## Lindsay Haigh

**From:** Nigel Hunston  
**Sent:** 20 December 2017 10:01  
**To:** DCAdmin  
**Subject:** 2016/91573 at location Cellars Clough Mill, Manchester Road, Marsden, Huddersfield, HD7 6LY

APARTMENTS

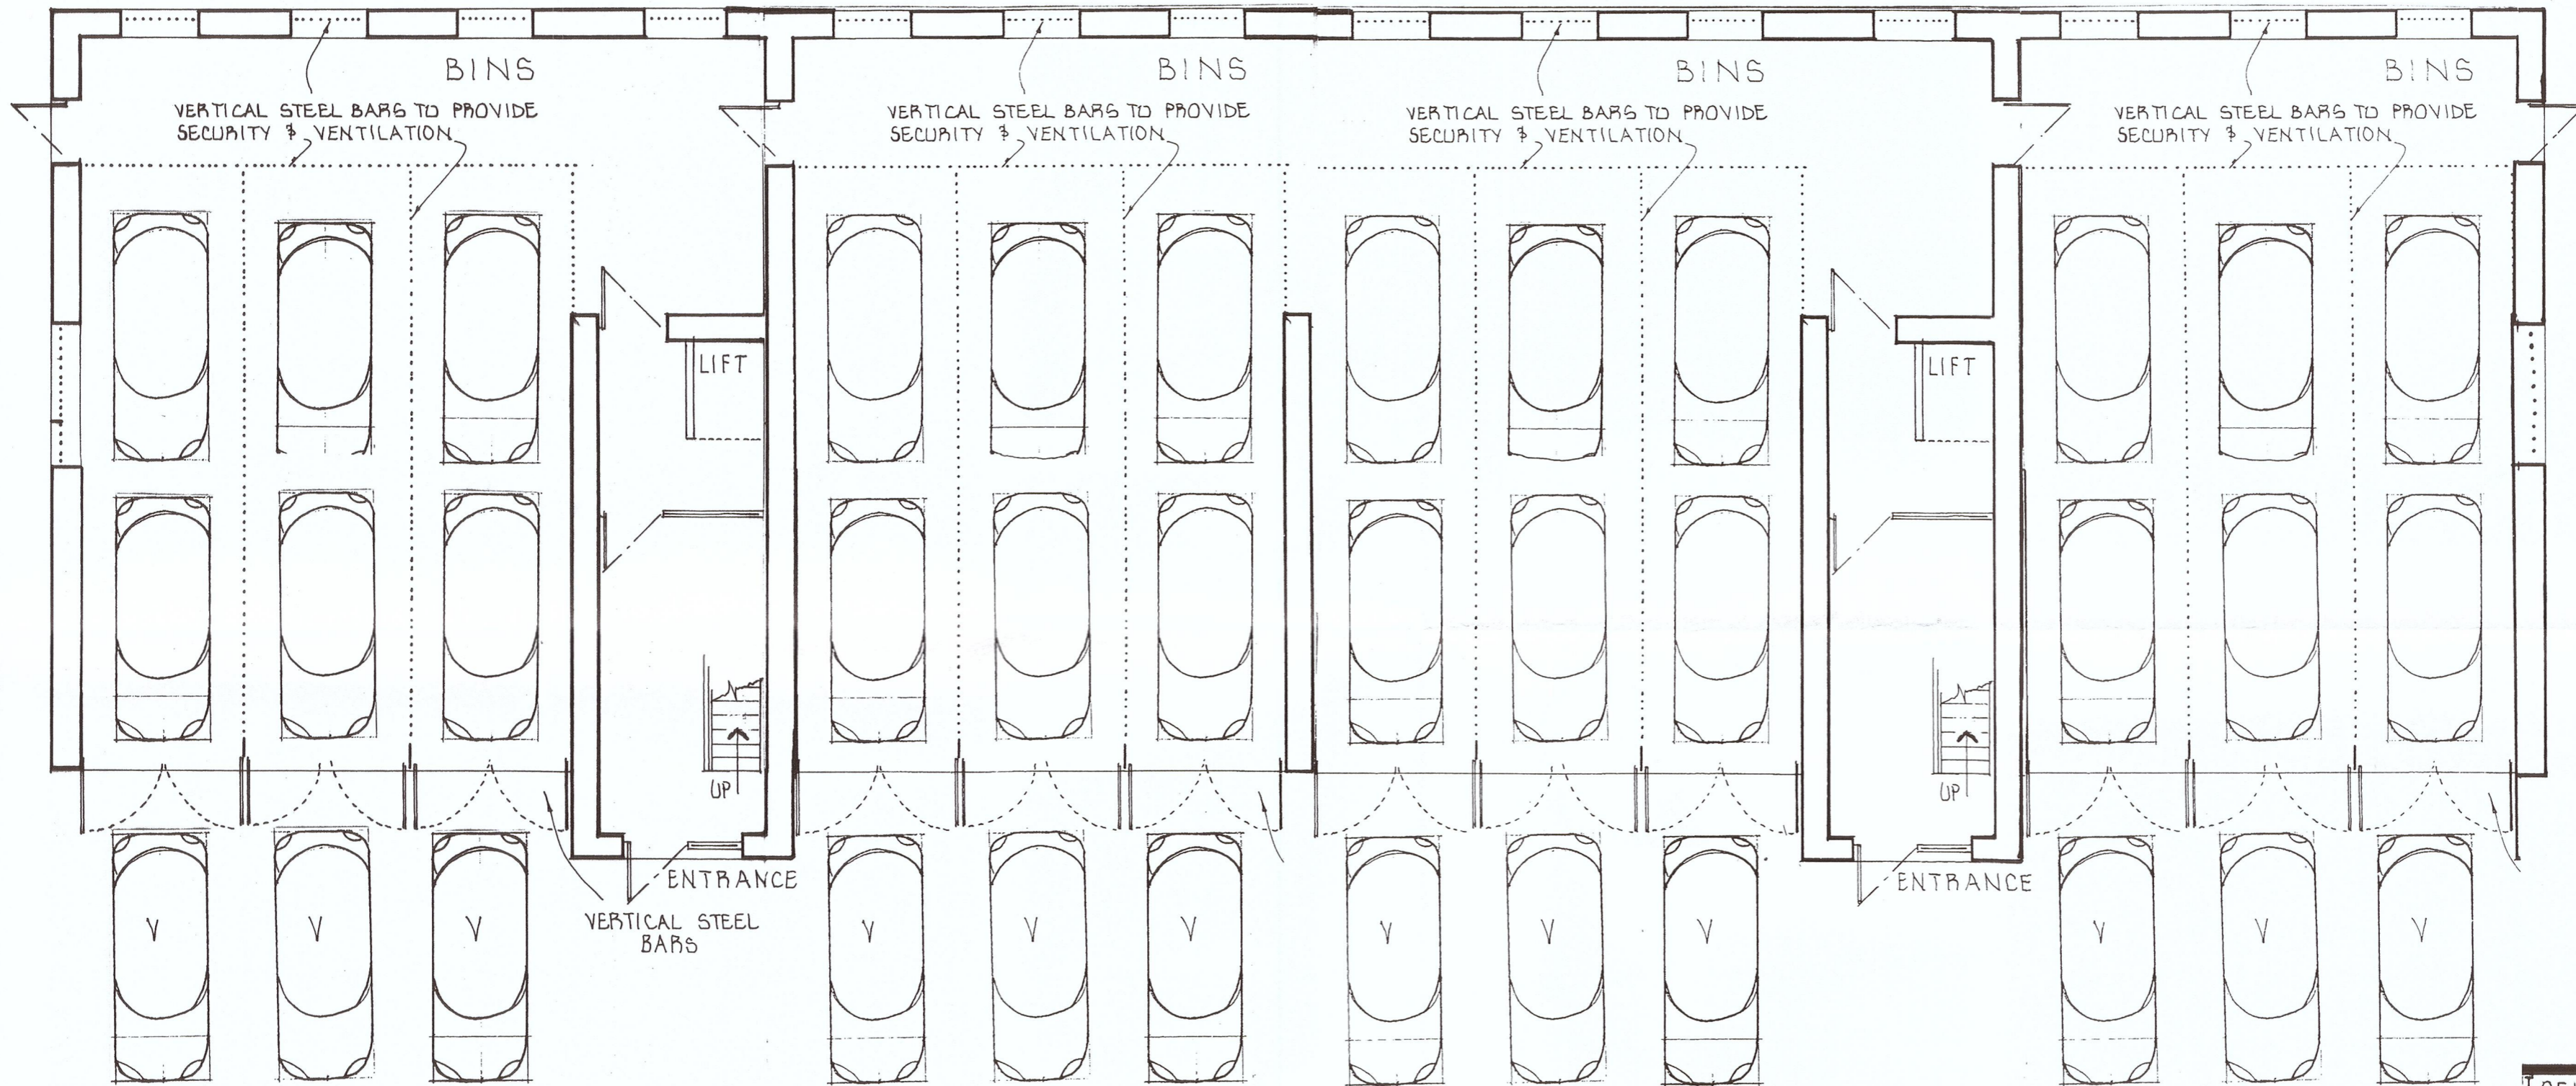
- French doors on the top floor of the apartment block do not fit into the character of the building
- How does the access road work? Is it a one way system, as the width would suggest or one way to the north with a two way system to the south? The arrows are confused to say the least! I defer to my highway colleagues. York stone paving for a highway is not a good practical way of surfacing though.

- Car parking-is this an annotation error? This many Visitor Spaces? Visitor spaces immediately in front of the apartments with the residents parking in a courtyard at the far end of the block? Those parking their cars in the courtyard who live in Plot 1 to 19 will be inconvenienced by this which may lead to parking on the road.
